Your Ref :
Our Ref : LU/112/18/NMA

Application for a non-material amendment following a grant of planning permission LU/252/17/HH relating to addition of 2No. Velux windows to proposed roof (one to north roof slope & one to south roof slope). Addition of cedar cladding to new rear gable at first floor level
51 Lansdowne Road, Littlehampton, ,

Drawing Title: Proposed Plans and Elevations		
Drawing Number: 1112.02.e		
Scale: As stated printed @ A1		
Date: 20/07/2017

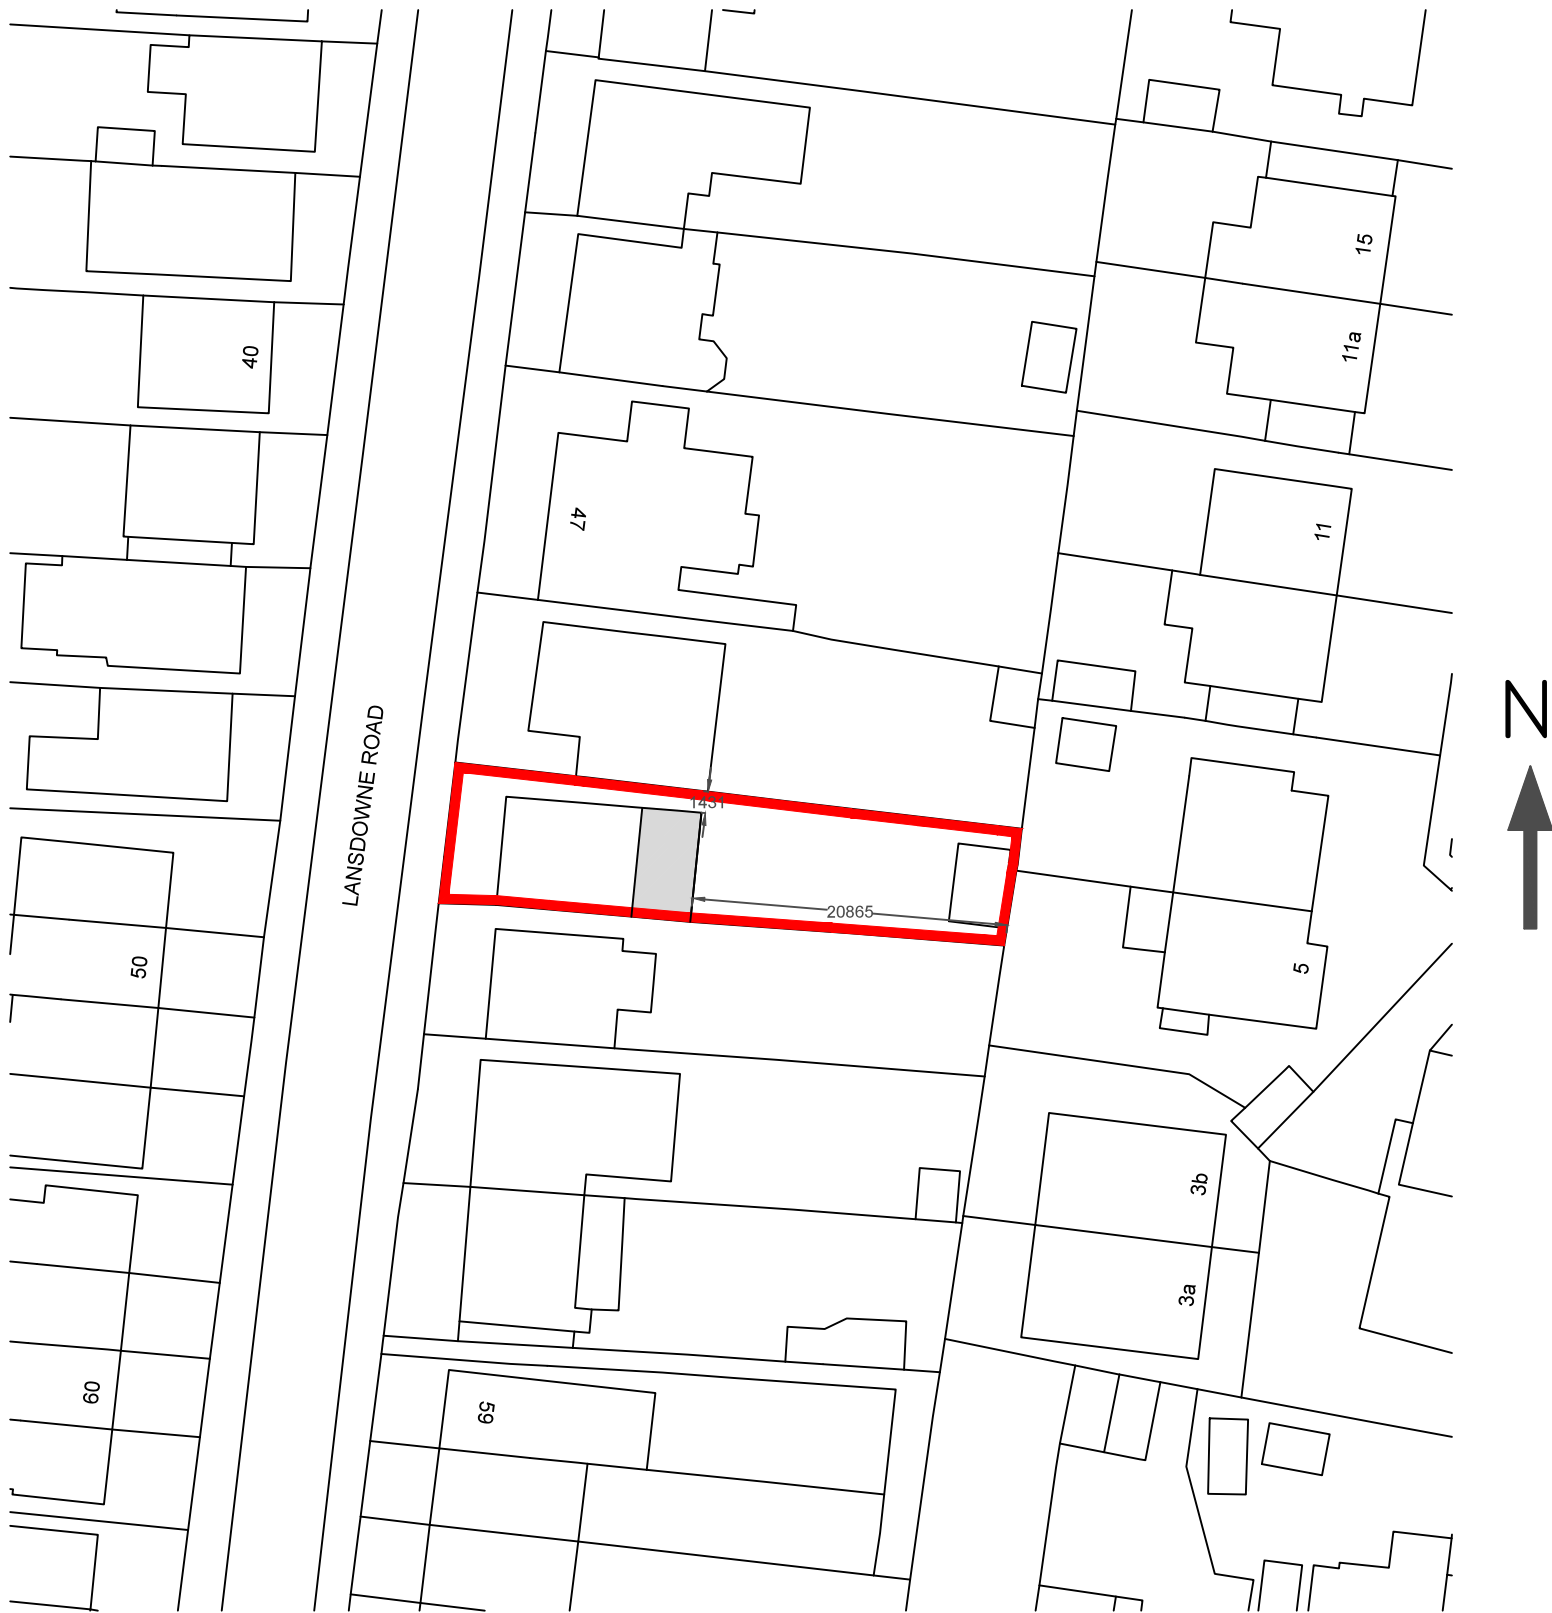
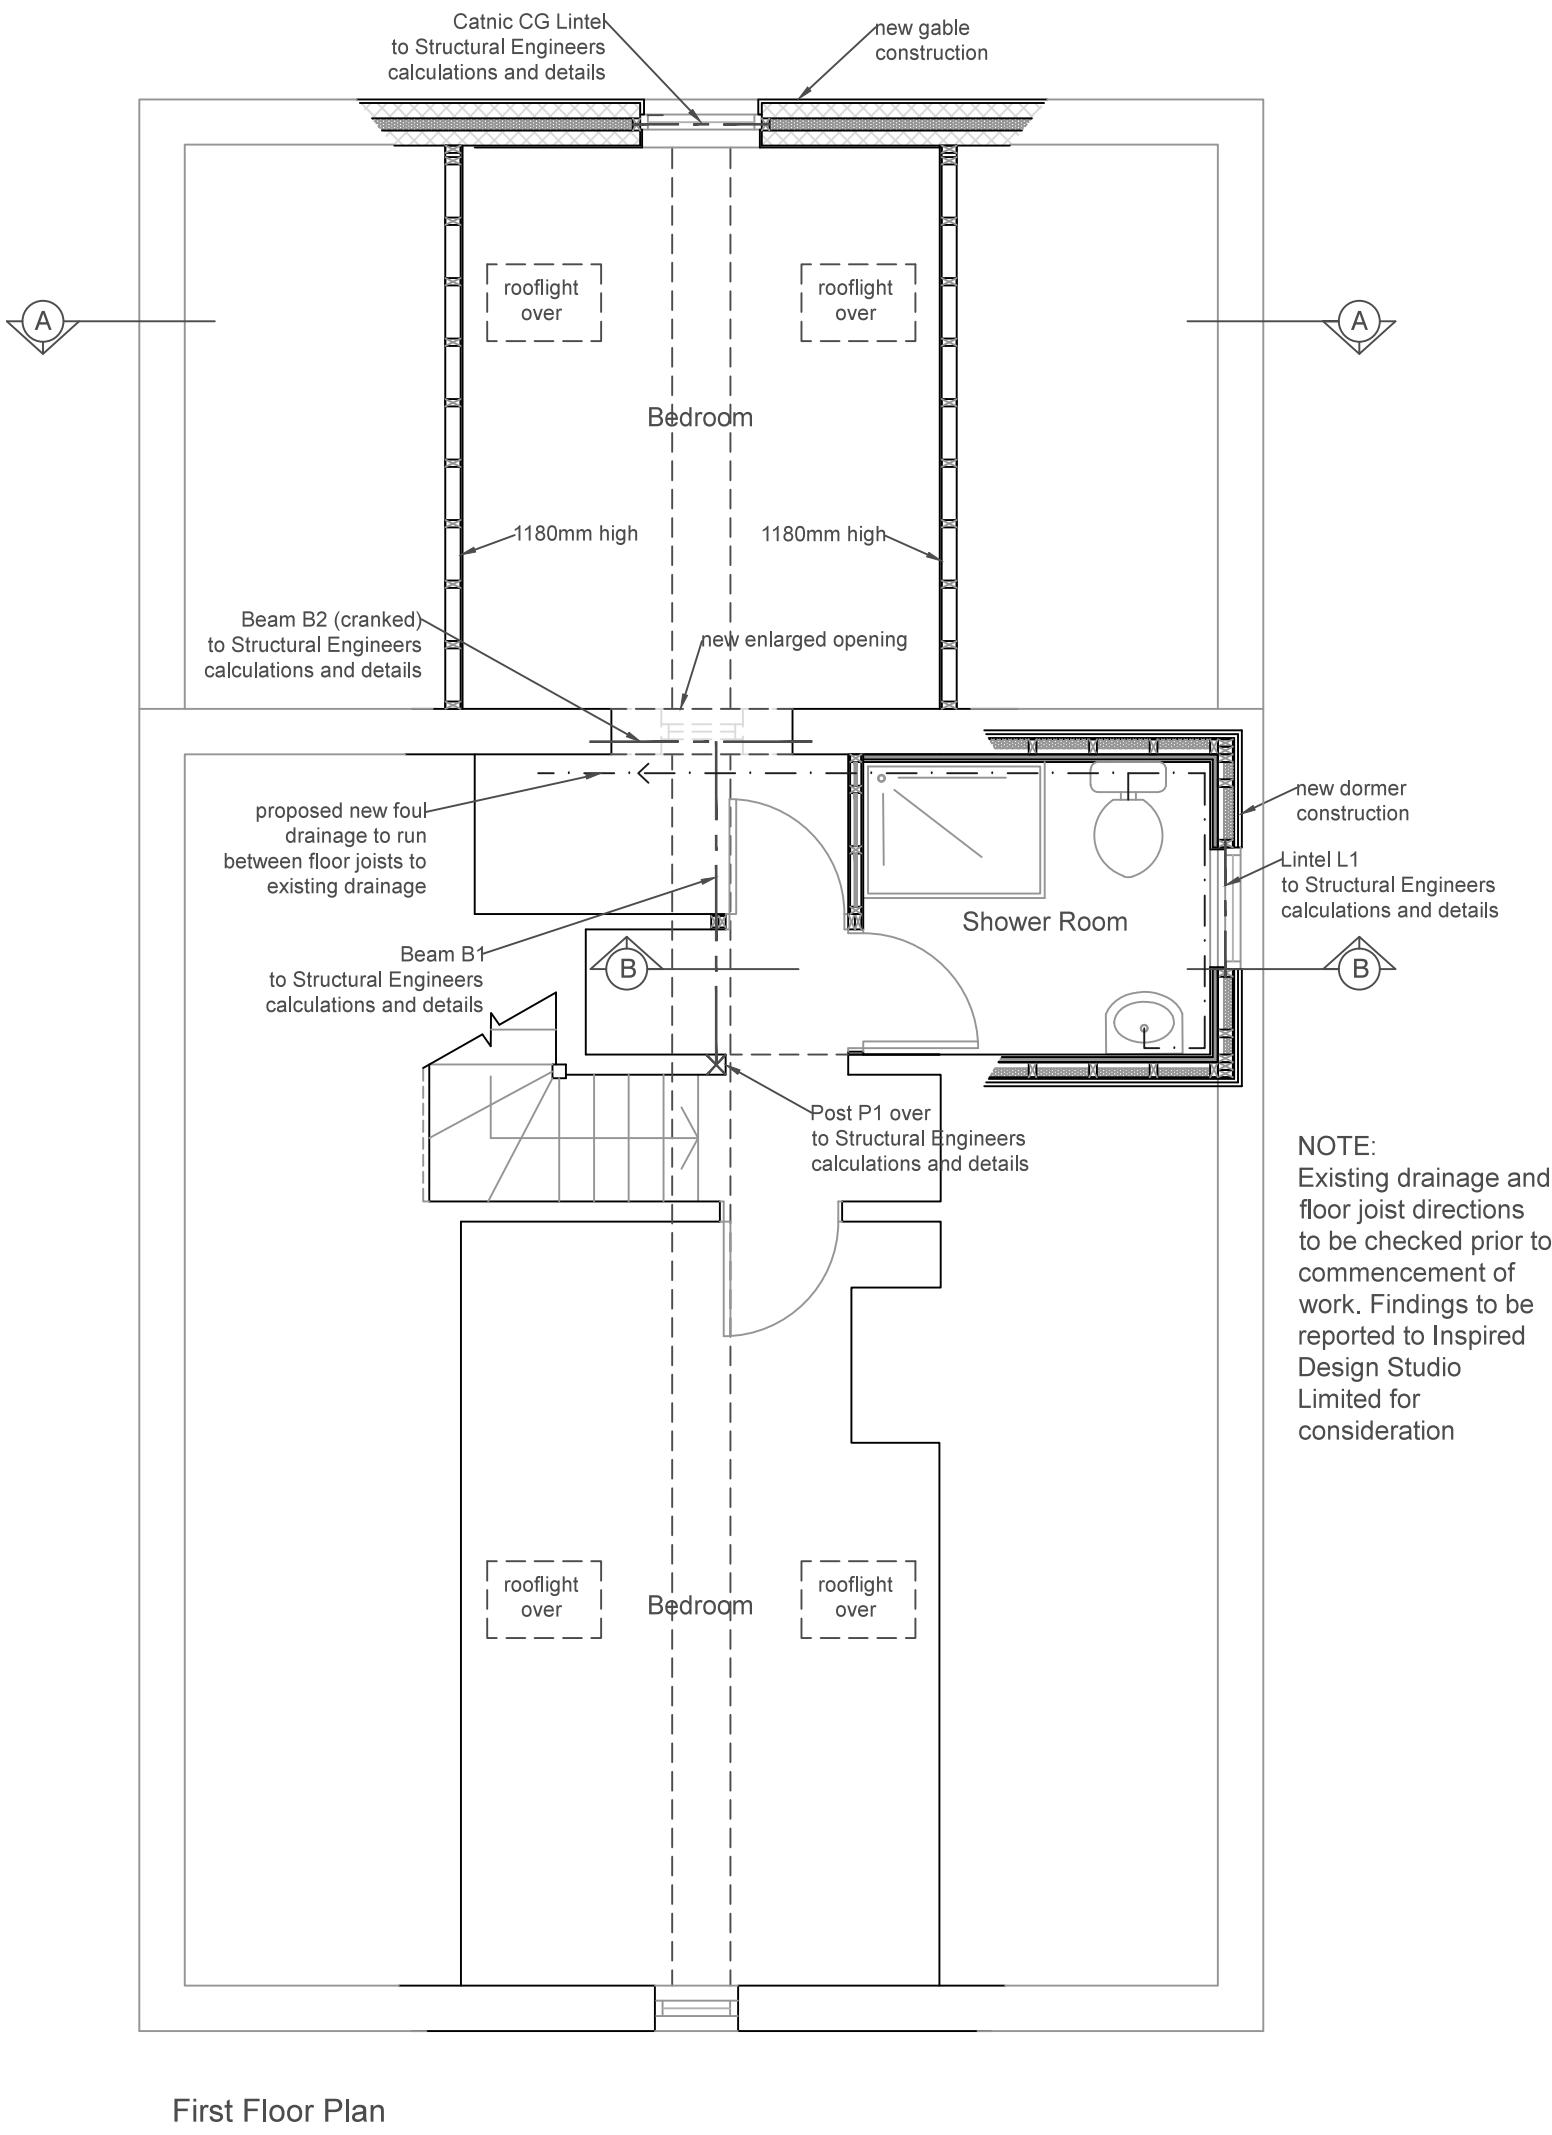
I refer to your recent application for a Non Material Minor Amendment. I note that you propose to add 2 roof lights, one on the north and one on the south elevation, and the provision of cladding to the rear gable.

The reasons that these proposals have been accepted as a Non-Material Amendment is because the changes do not materially alter the planning permission and do not necessitate additional consultation with local residents. It is noted that the new additional roof lights would face onto the site side boundaries, but the eill heights would prevent a material loss of privacy to neighbouring properties. The changes can therefore be considered as an NMA under section 96A of the Town and Country Planning Act 1990.

Please note that Drawing 1112.02.e "Proposed Plans and Elevations" has now become the approved plan for planning permission LU/112/17/HH.
